Glennies Creek Part 3A Application - Longwall Panels 10-17 Middle Liddell Seam

Response to Submissions

Glennies Creek Coal Management

February 2008

Figure 2.2 Bettys Creek and Glennies Creek Coal Mine Longwall Panels 10 to 17

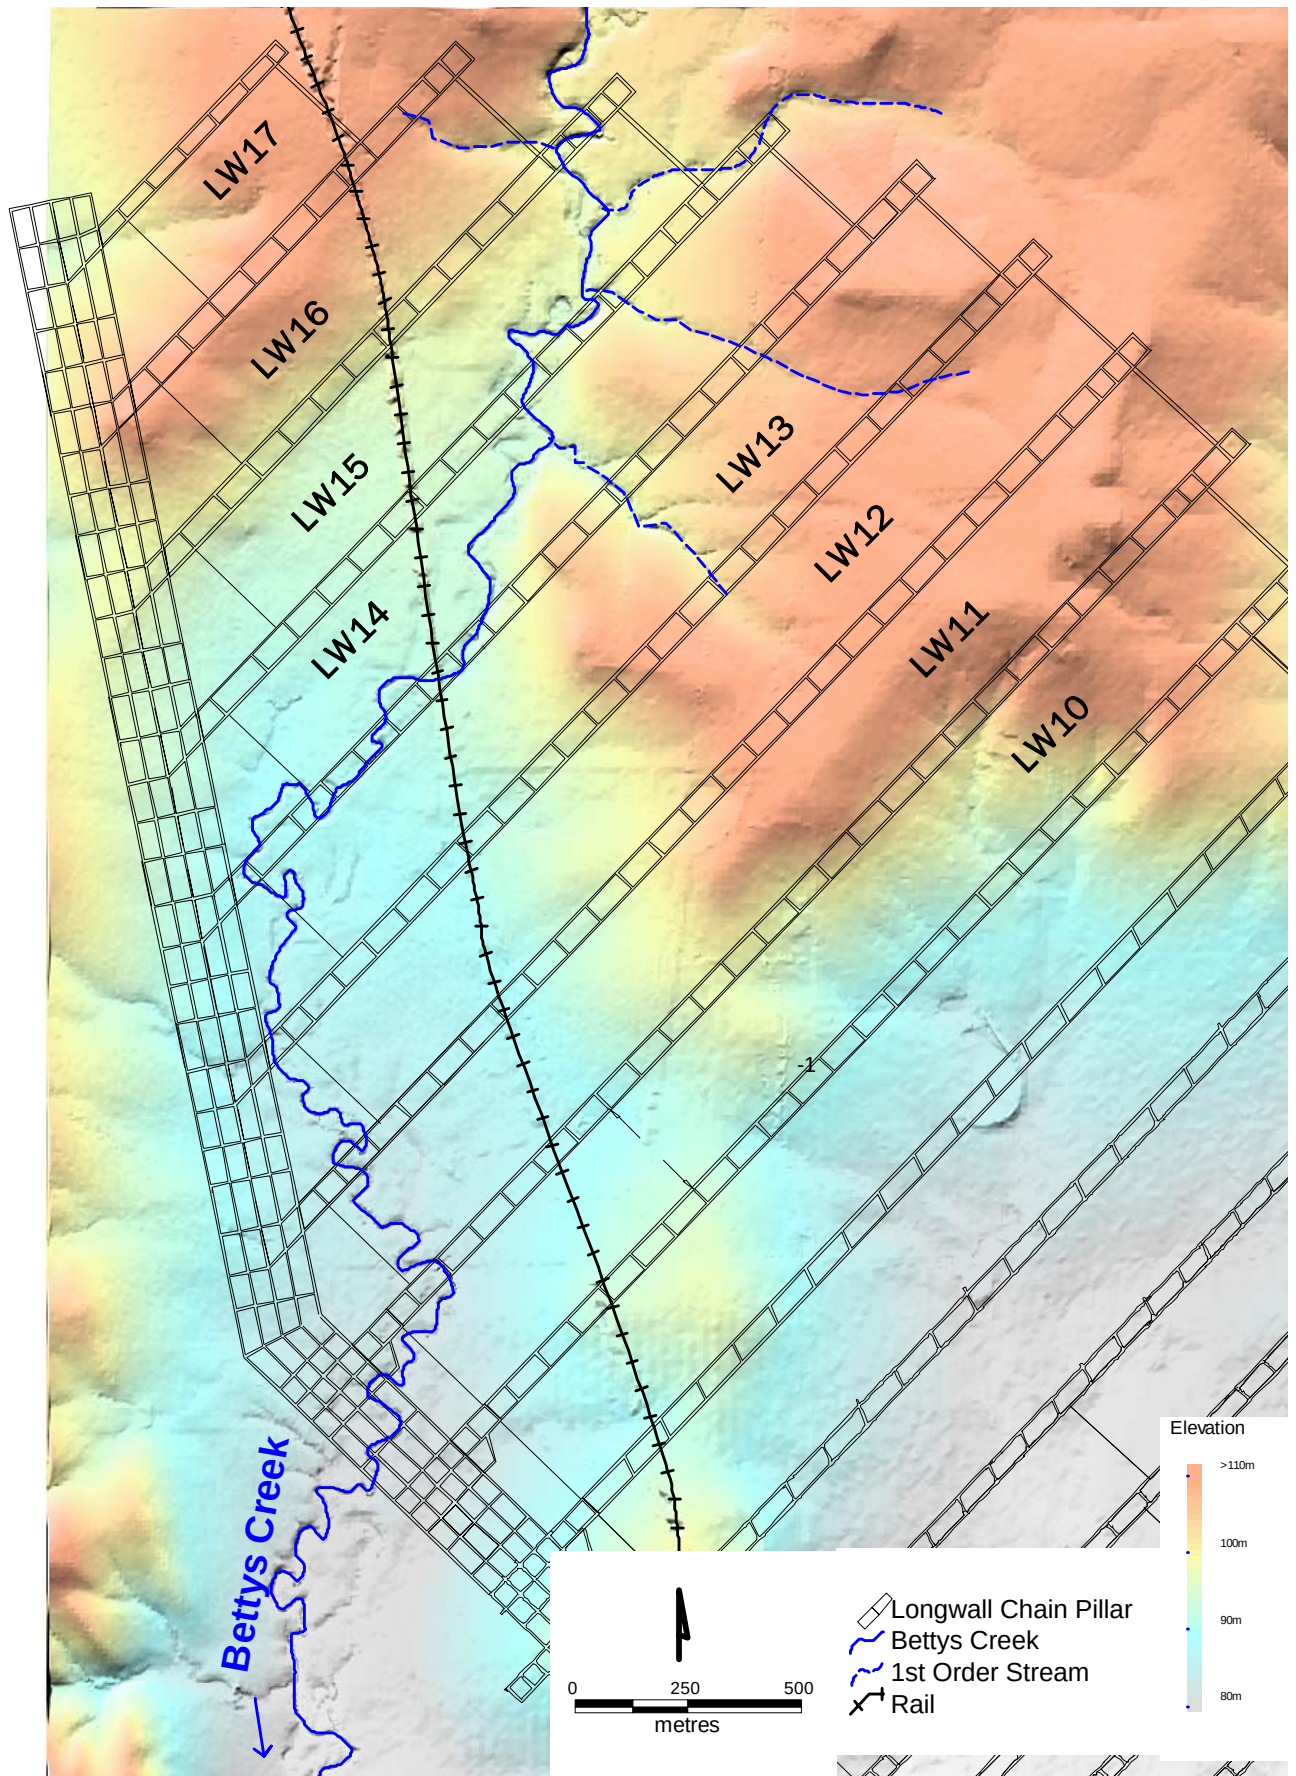
The Department of Lands submission notes that there are unidentified Crown roads on the Project Area. Staff from ERM and the Department of Lands have previously discussed this issue and have noted that *Figure 2.2* of the EA indicates Crown Roads, albeit without specific keying to indicate their status.

In general terms, subsidence will cause predictable deformation of the ground surface so that improvements such as roads may develop dips. There has been no cracking observed to date at GCC. Forest Road is lightly trafficked and the Subsidence Management Plan currently lodged with the DPI details proposed subsidence management procedures. Subsidence observed in earlier mining sequences shows that Crown road closures will not be required and ICO does not expect that any formed or unformed Crown roads will become untrafficable as a result of mine induced subsidence.

ICO commits to restoring to previous condition any Crown road damaged by mine subsidence or associated activities where these roads will not be subject to further disturbance by Xstrata. This is reflected in the revised Statement of Commitments in *Annex A*.
